Listed building consent for the replacement of 2 No. windows & 1 No. door with PVCu Heritage Flush type to rear elevation & removal of walls in upper second floor for open kitchen plan & replace boxing with enclosure in lower hallway & reinstatement of handrail to match existing.

Second Floor Flat 37C South Terrace Littlehampton

Thank you for your internet representation made on 20th April 2020 which has been recorded as **'an objection'** with the comments as follows:

Proposed East Elevation of Rear Outrigger - 1/100

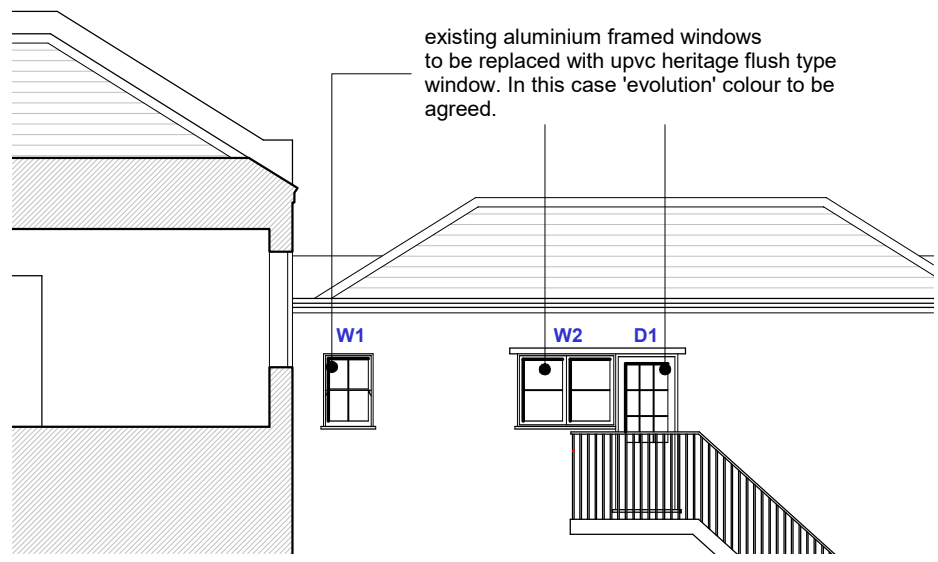
Use of PVCu within a Conservation Area should not be permitted however, more appropriate materials such as wood or powder-coated aluminium should be utilised.
